January 24, 2024

RE: Responses to Technical Review 1
White Barn Brown Bear Car Wash
8907 & 8915 Soper Hill Rd
City File No. PA23-021
Our Job No. 22681

Letter from City of Marysville dated December 5, 2023

Job Number: 22681  
Sheet: CWA2.1  
of

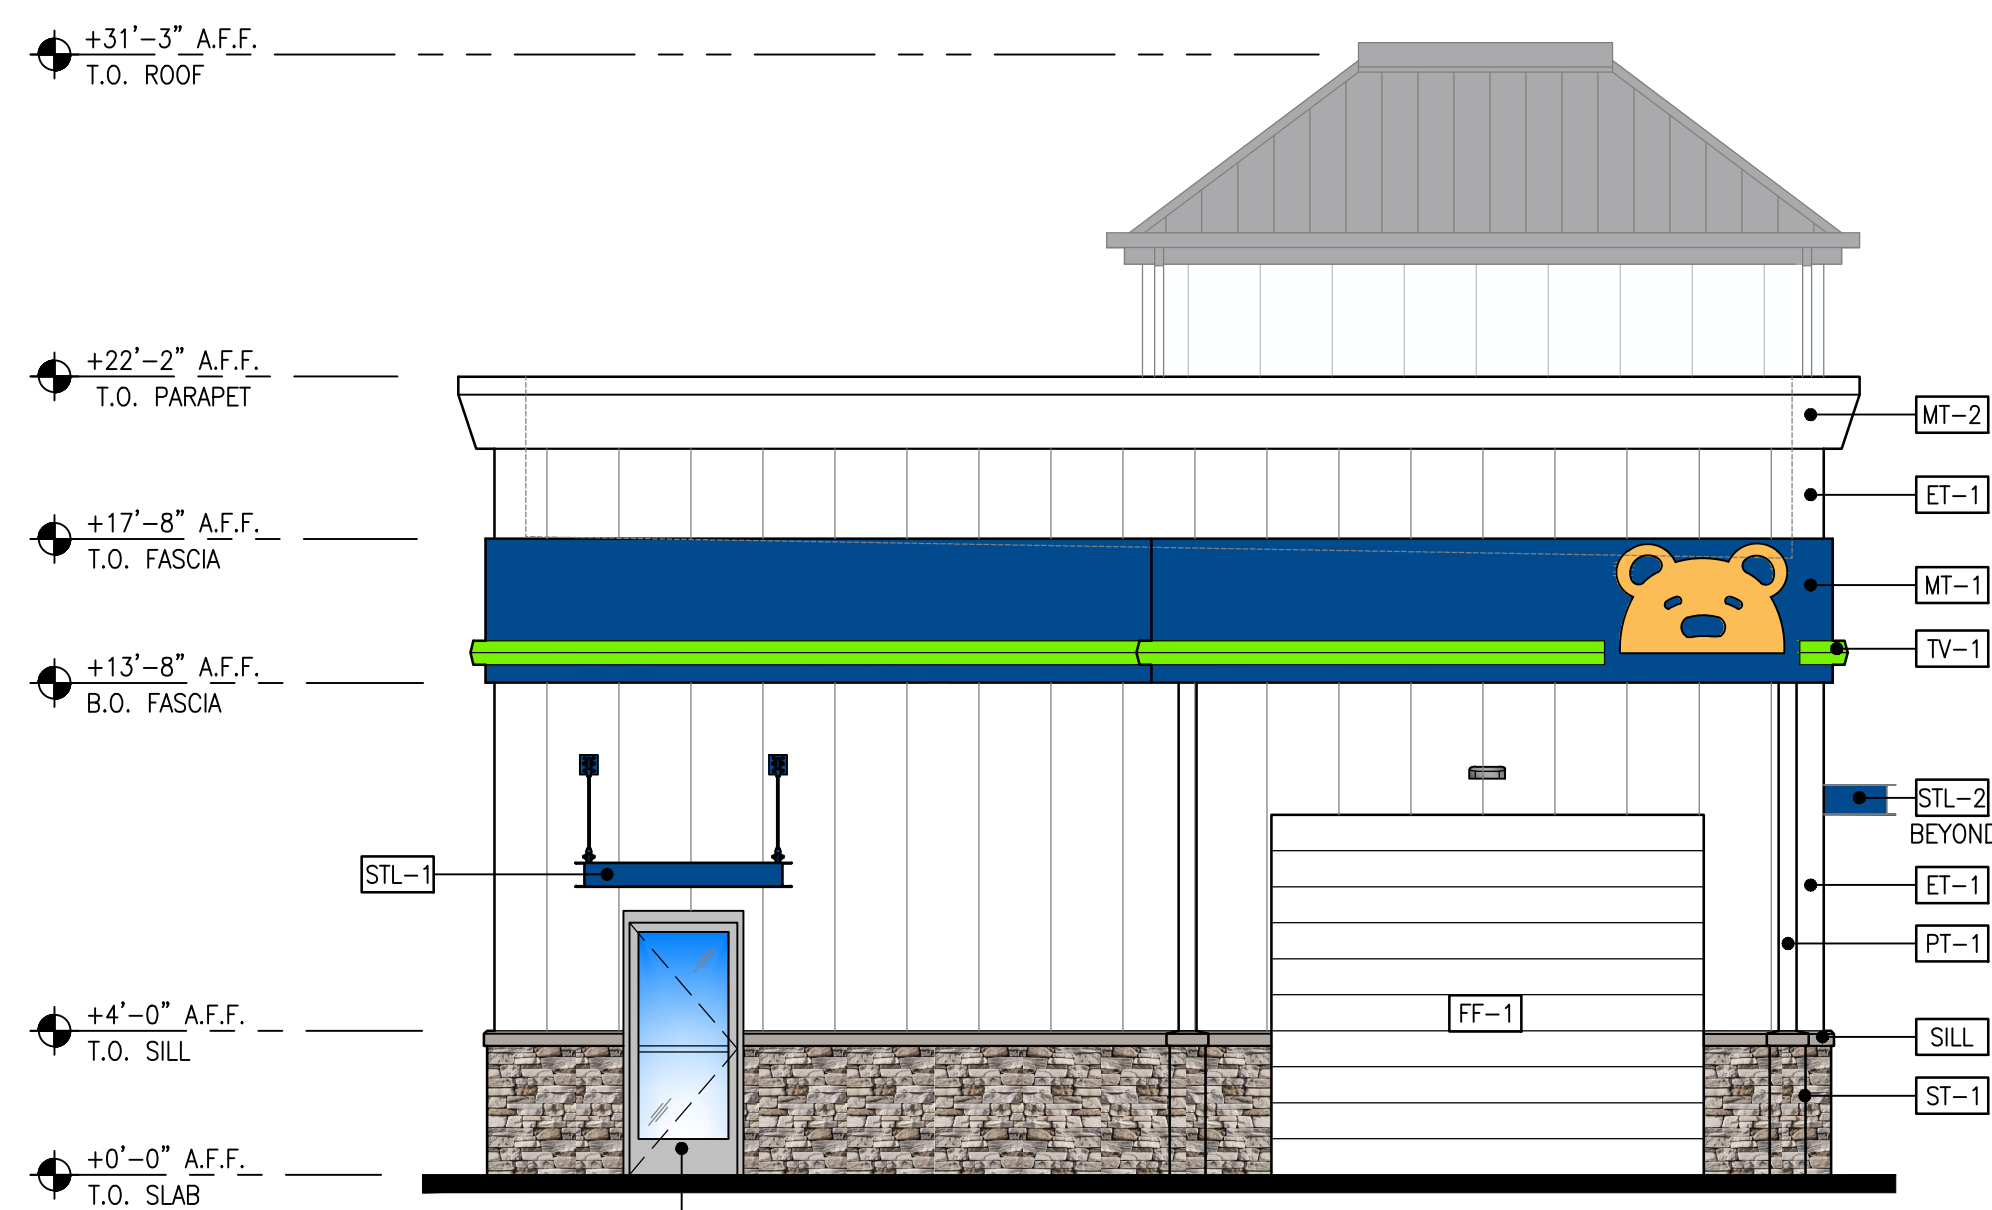
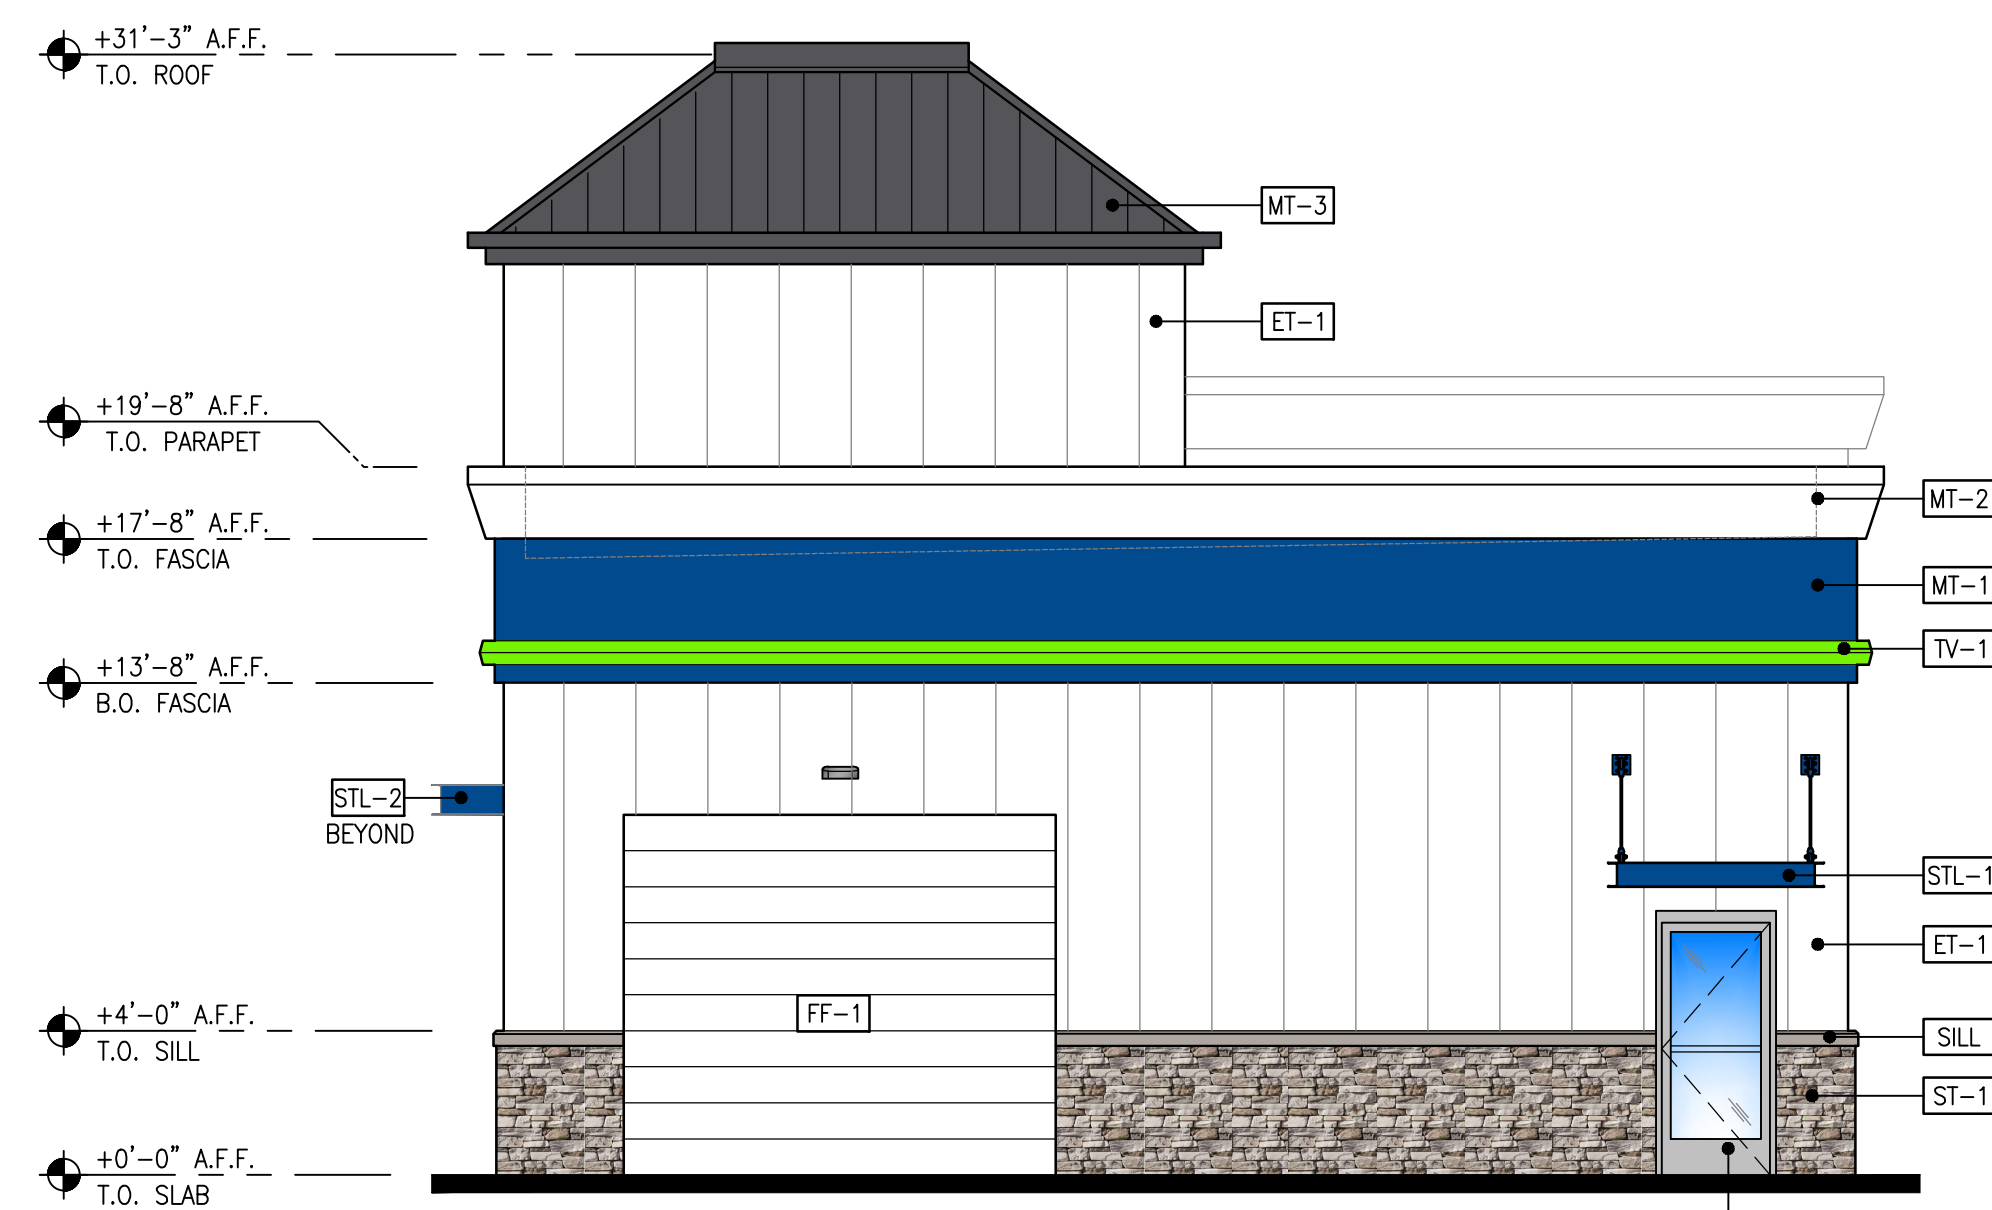
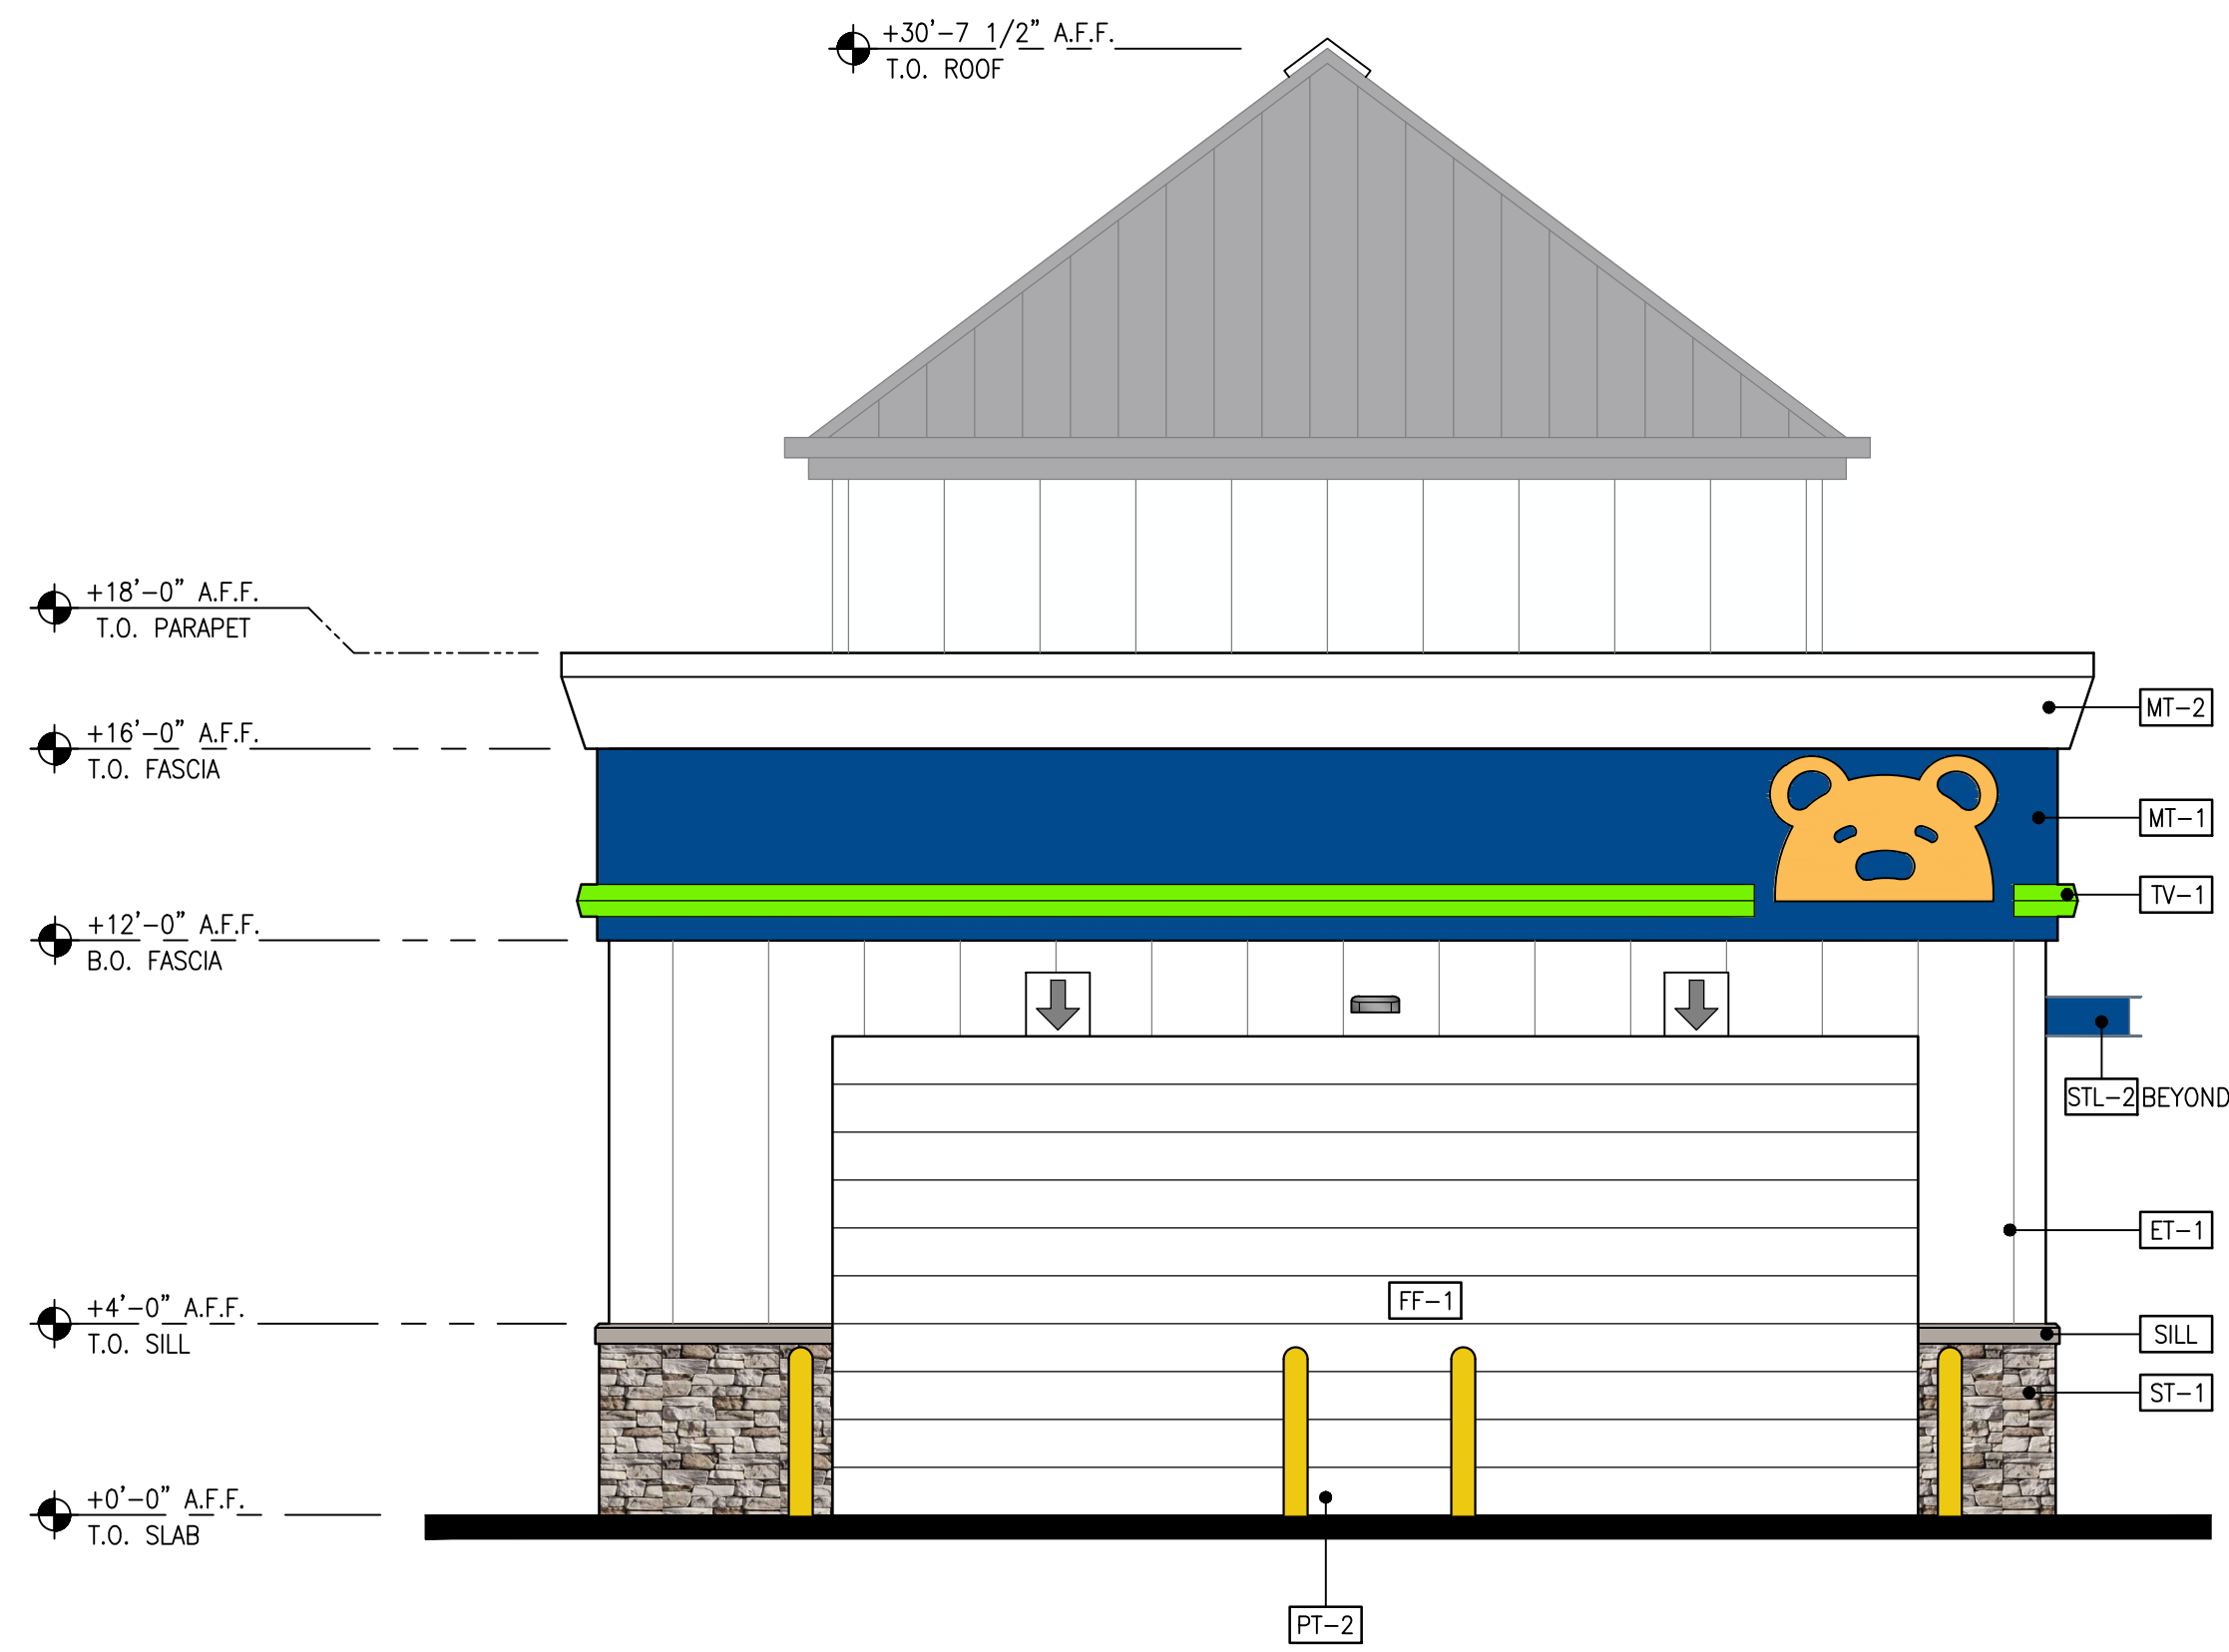
4. *To better meet the intent of MMC 2C.070.190(2) in regard to building details standards, architectural design elements should be included the windows and doors (i.e. awnings, trimming, recessed entries, decorative doors etc.).*

4.1. *Demonstrated compliance with (2)(d) for blank wall treatment is needed. Especially for the east/west elevation of the Self-Wash building.*

Response: Please see the provided revised color elevations, demonstrating compliance with blank wall treatment requirements.
